Please include the following:
PCD File No. BOA245

LOT 19 BLK #2
BRADLEY RANCH FIL #3
PHASE 1

V1 - Site Plan Drawing - Redlines.pdf Markup Summary

SHED

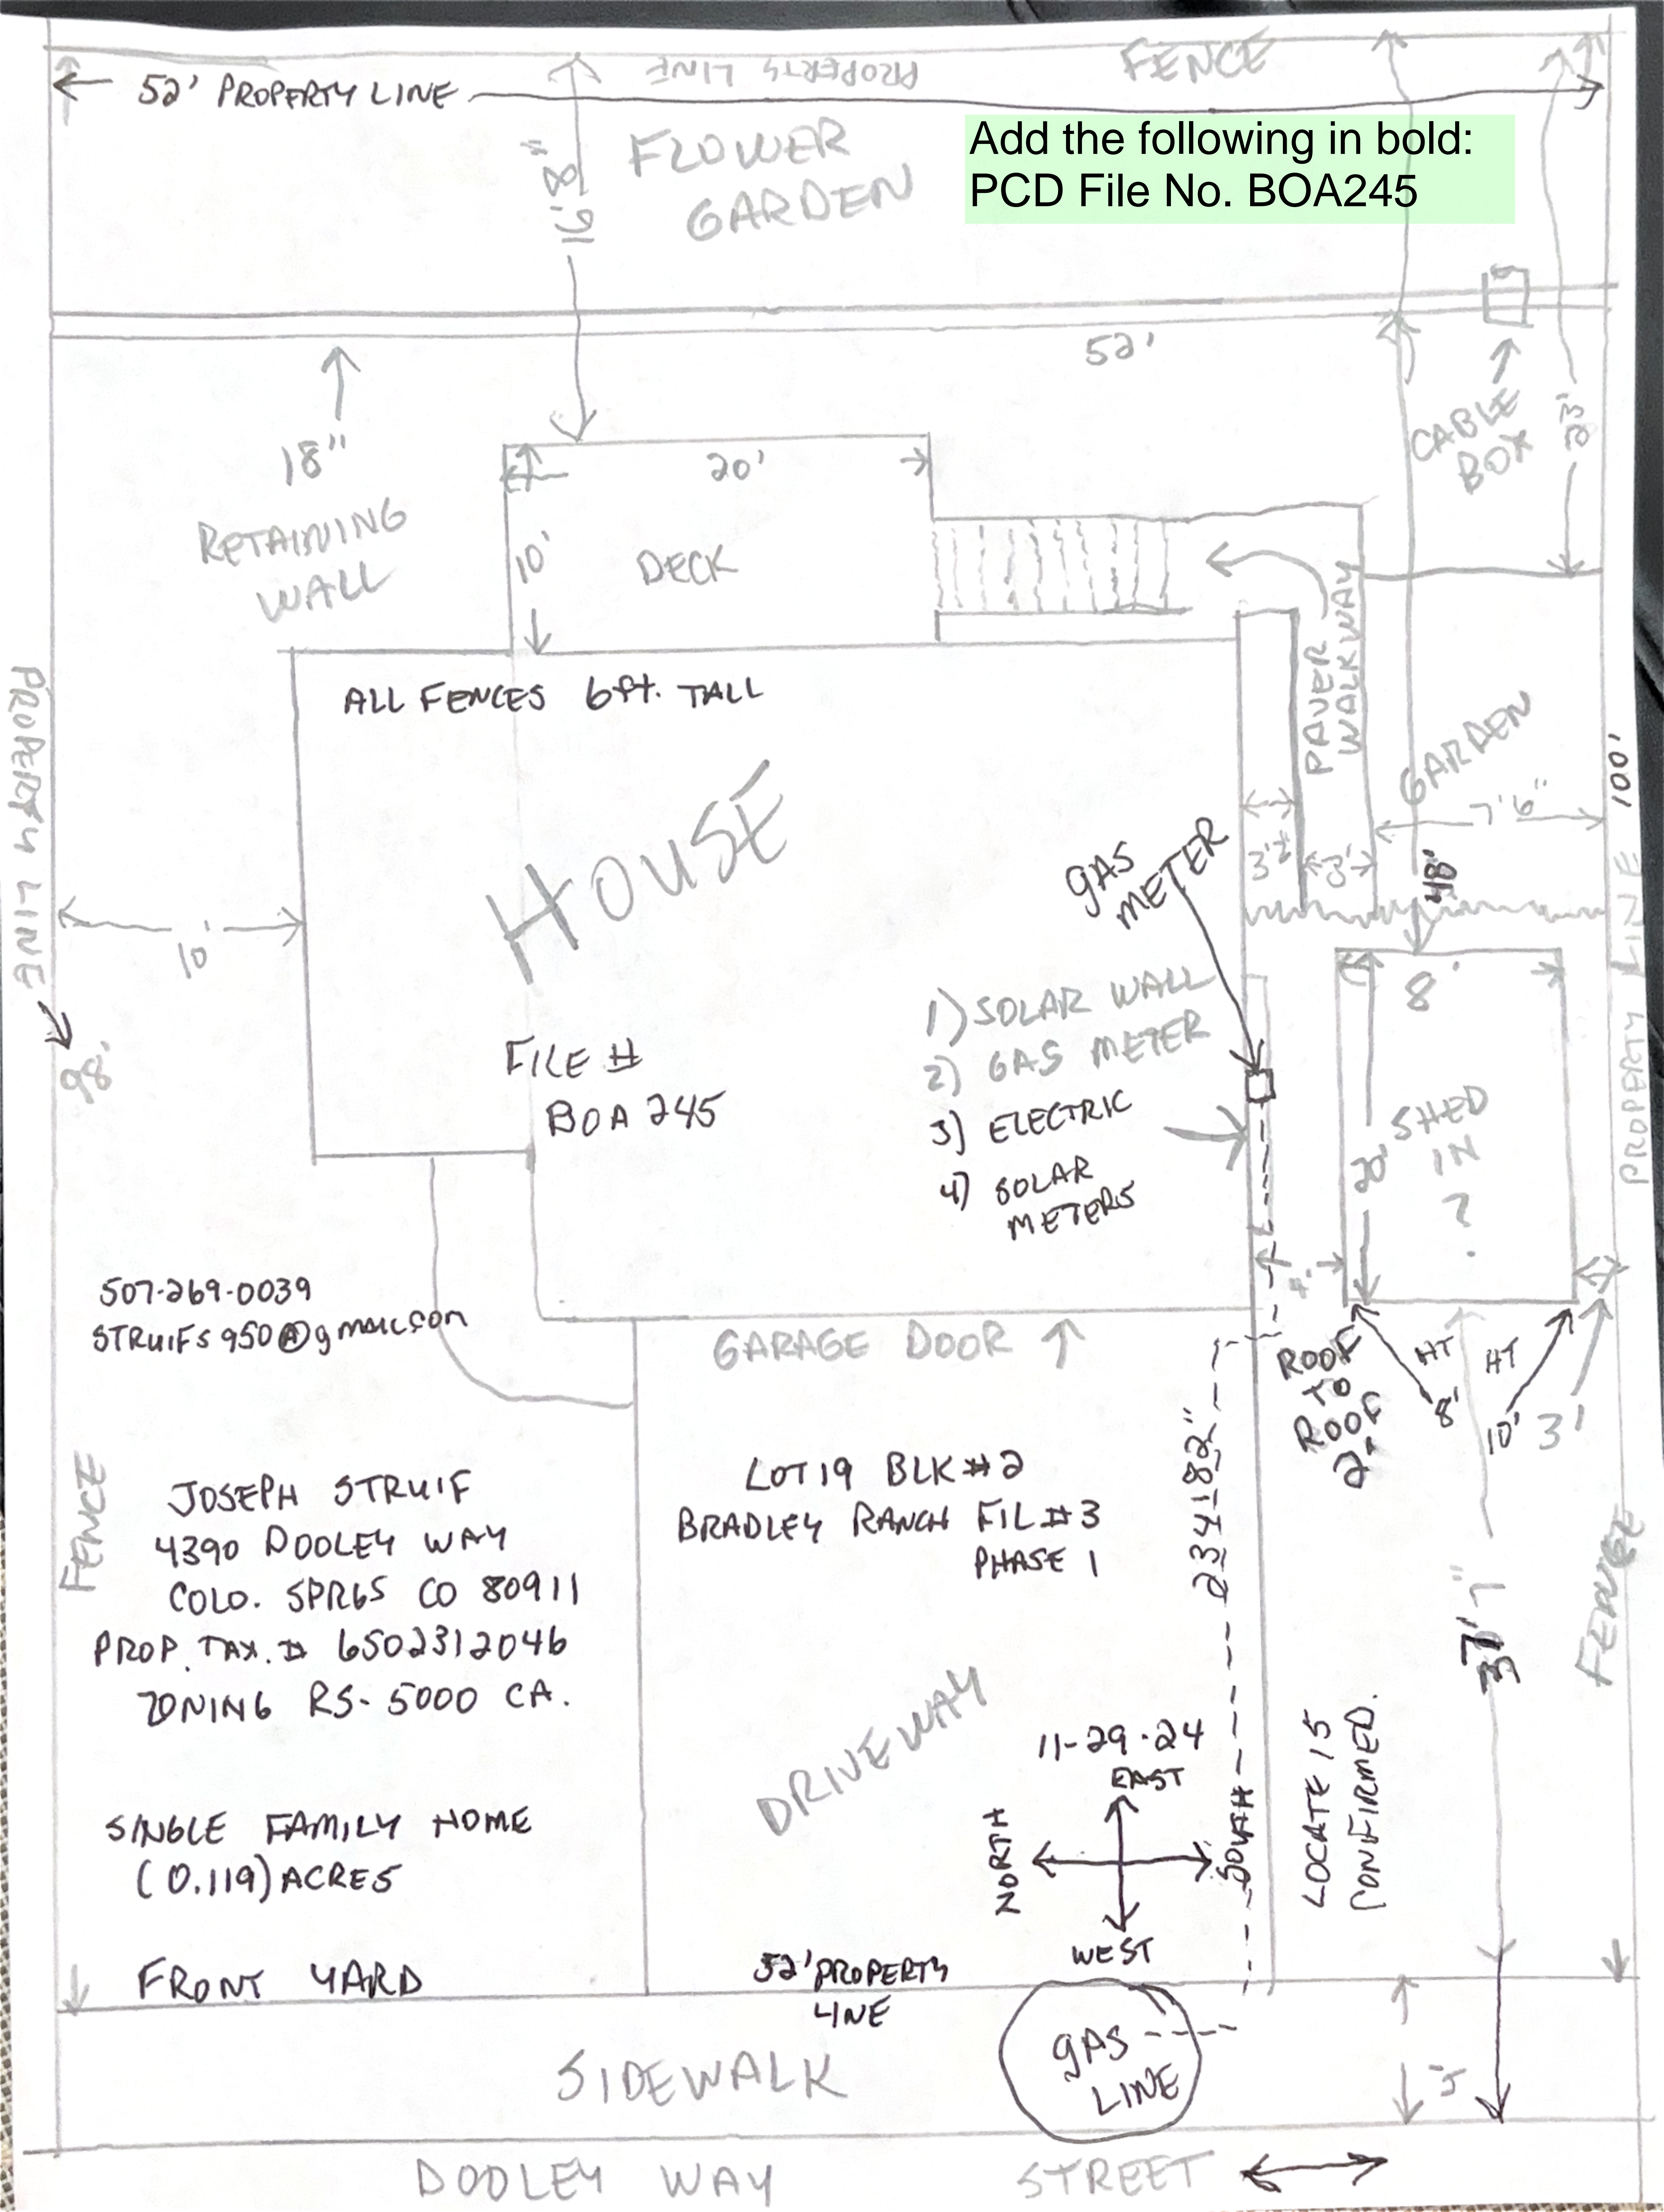
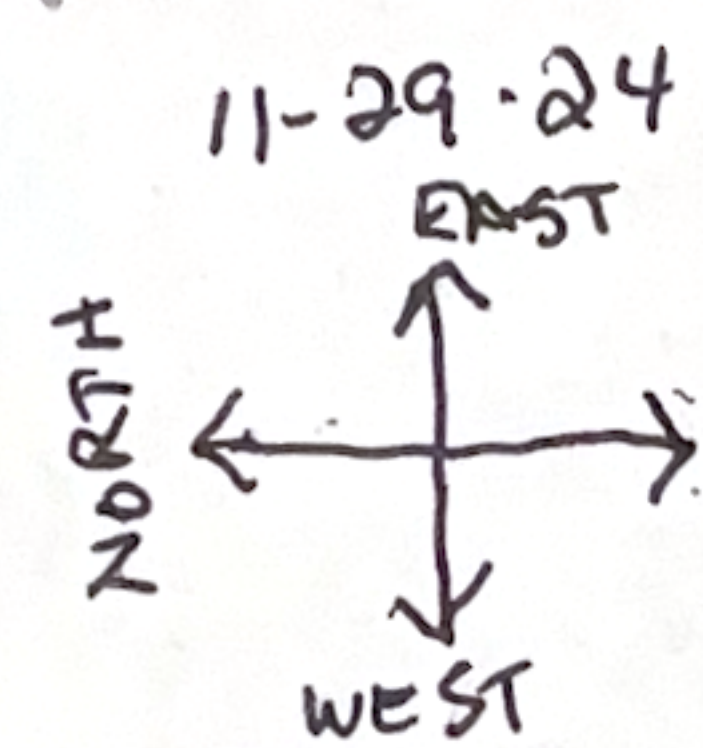
Please include/label Dooley Way Right of Way line and include dimensions to the shed or other landmark.
Note: Dooley Way has a 60' wide ROW.

Please include shed height.

Please include the following:
PCD File No. BOA245

Having a permanent structure over a public utility easement requires an easement release letter on utility company letterhead from each utility company. Please reach out to all the utility providers in your area and request the required easement release letter. Additionally, the structure is built over a drainage easement. A letter is also required from the Drainage Board.
